PORTLAND MAINE

August 5, 2011

Re: 120 Baxter Boulevard – 111 B006 – R-5 – Permit #2011-07-1709
17 Codman Street – 129 G011 – R-3 – Permit #2011-07-1712
209 Stevens Avenue - 177 I010 – R-5 – Permit #2011-07-1708

PROJECT COVER SHEET

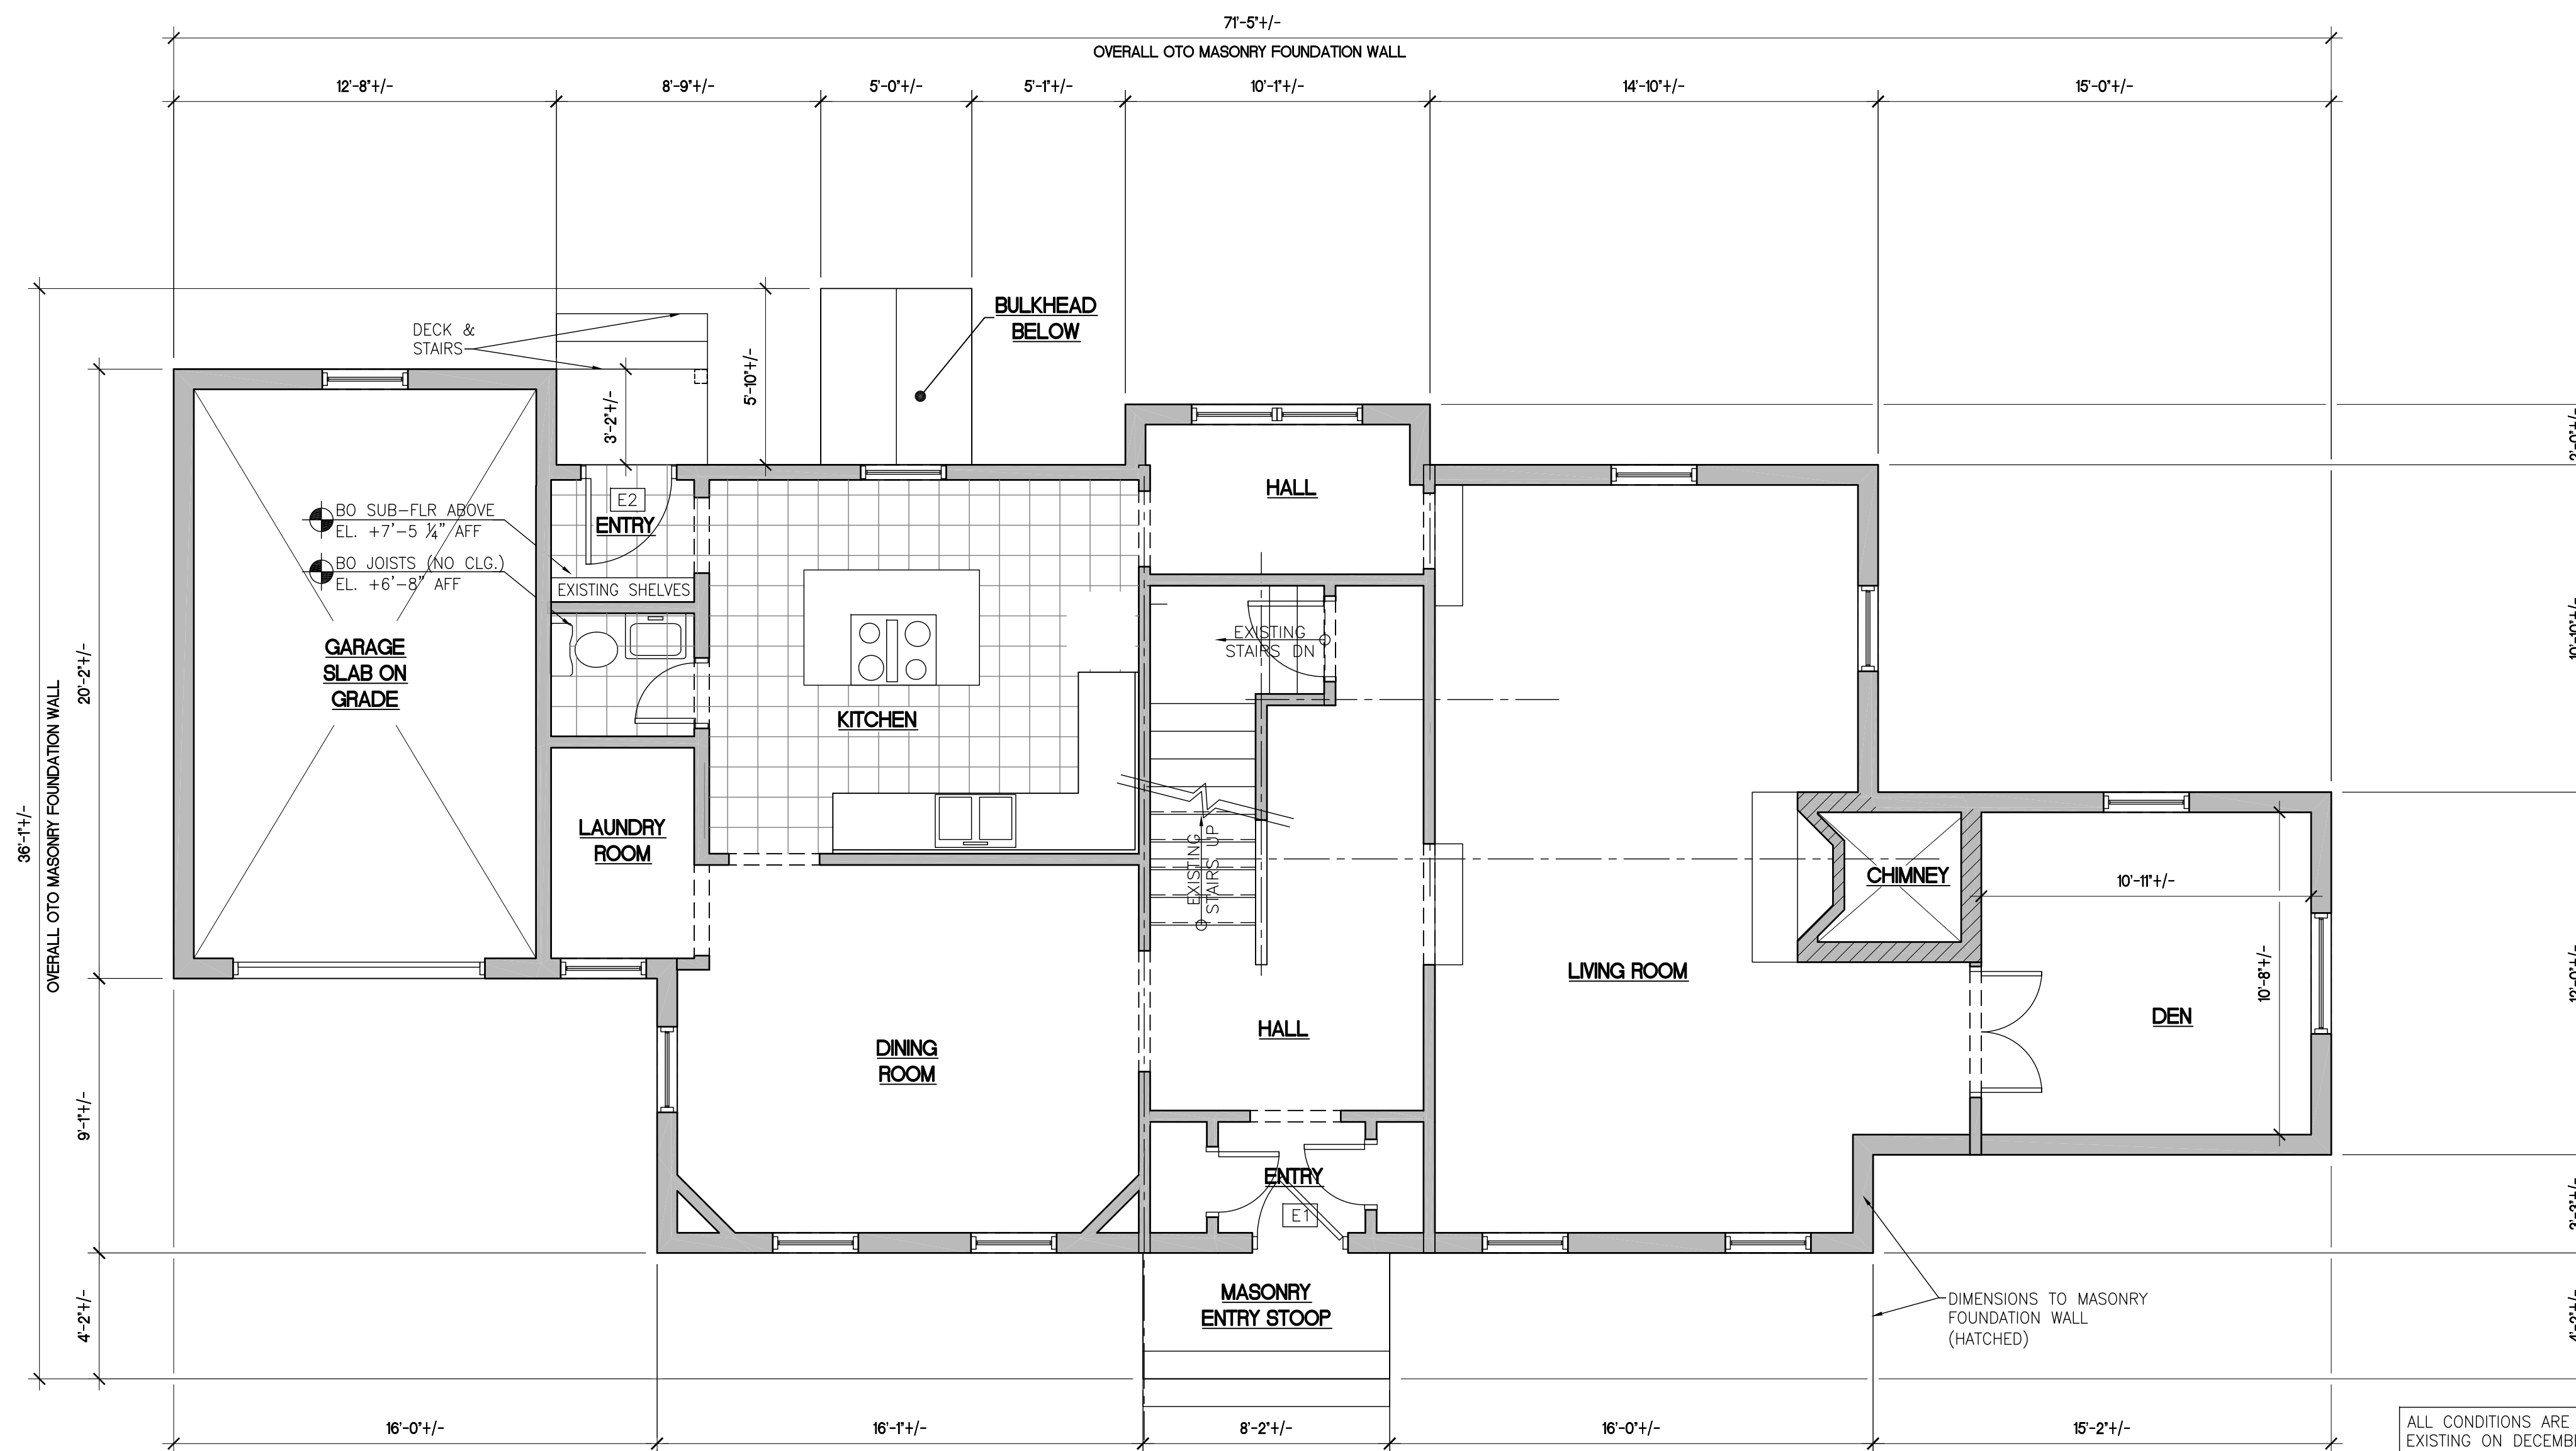
1. a specific list as part of the project description that encompasses the complete scope of work that the permit covers. In other words, we need an exact, detailed list that spells out all the remodeling details that are included as part of the permit application.

2. as part of the removal of the kitchen in the basement level, all the kitchen equipment has to be removed including the sink, refrigerator and any appliances used for cooking. This needs to be indicated on the plan.

3. the area labeled “Artist Studio” in the basement needs to be removed
4. identify all the individuals who are currently residing at the property and indicate on the plan which bedroom each individual occupies.
